Your Ref: OWPC16500
Our Ref: A/190/17/HH 17-10-2017
Please ask for:
Mrs A Gardner

Erection of single storey detached double garage
Harcourt West Drive Angmering

DRAWING	PROPOSED SITE PLAN AND ELEVATIONS																						
Date	October 2017	Drawn By	PJC																				
Scale	1: 200 - 100 @A3	Iss. App. By	DKC

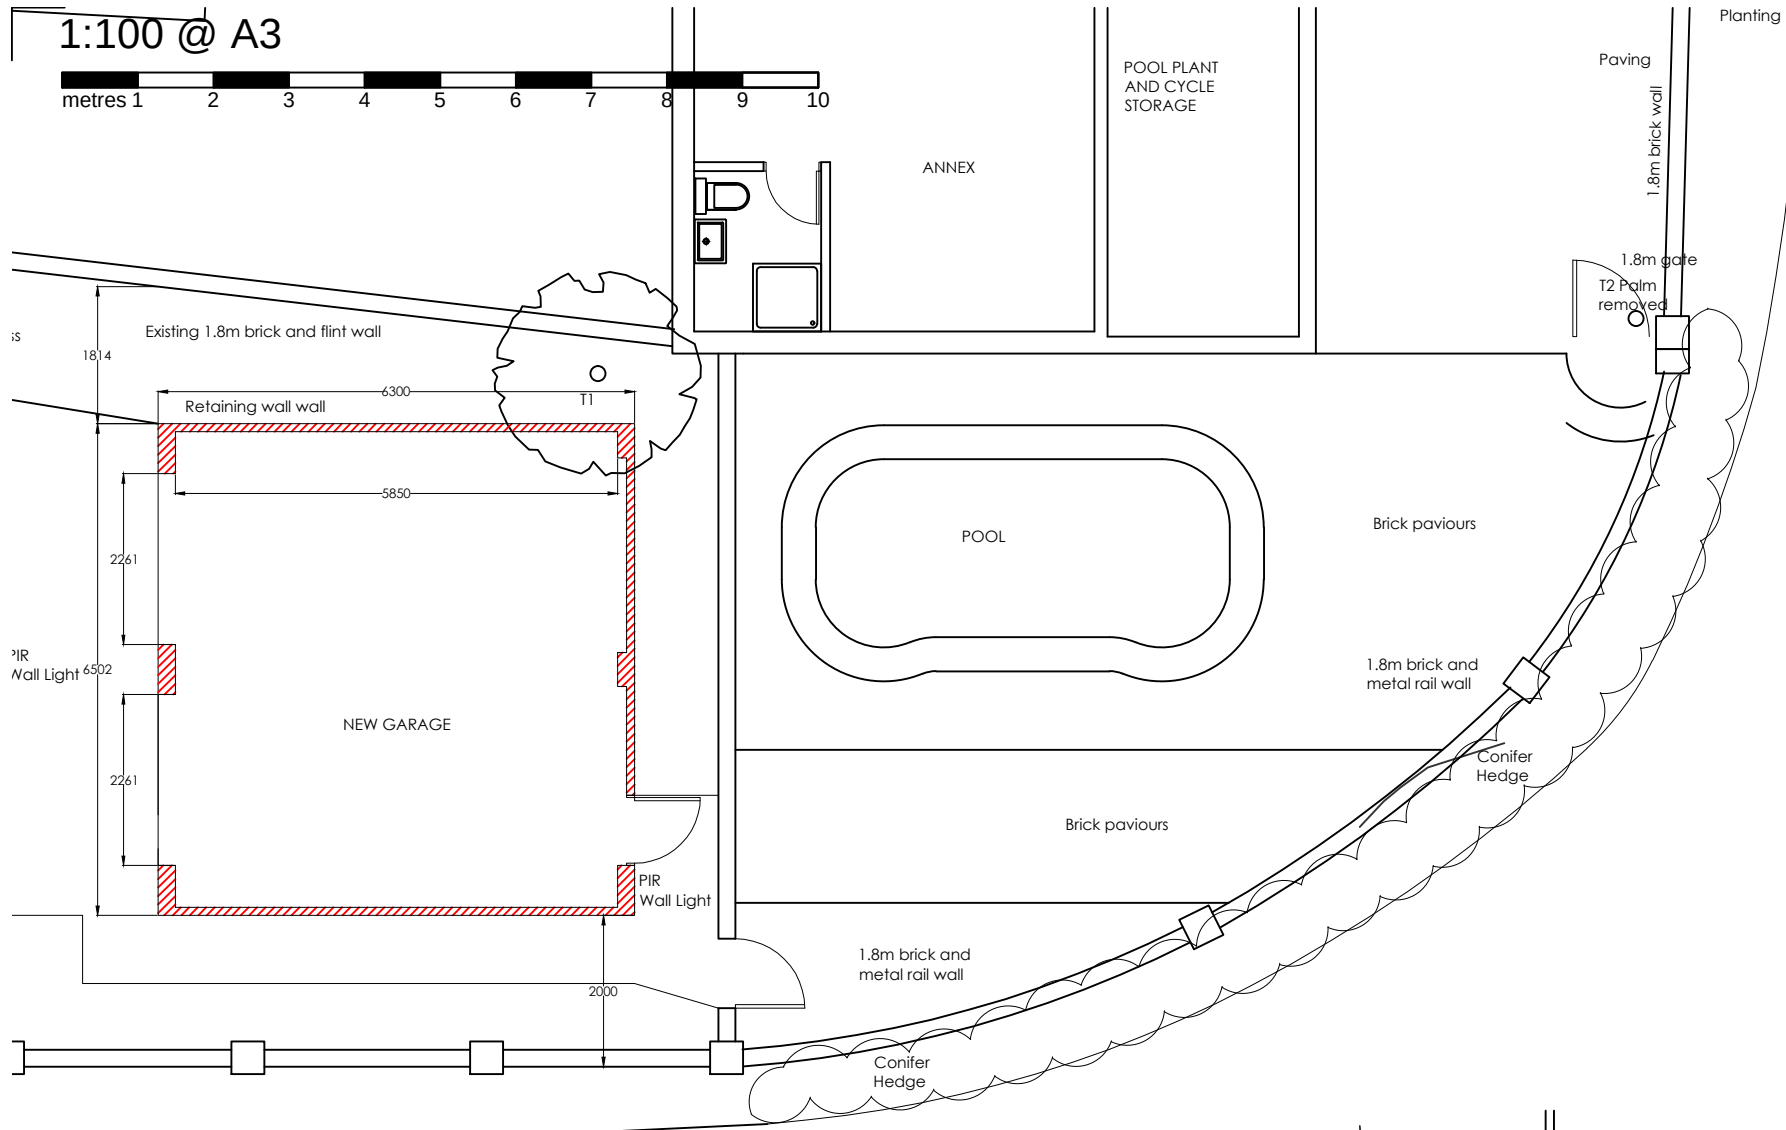
I object to this application. The access point is on to a junction, with a restricted view of oncoming traffic entering the junction from West Drive. The proposed new garage is outside the building line and would have a negative impact on the street scene. A separate dwelling could be created by transforming the extended garage into a bungalow.
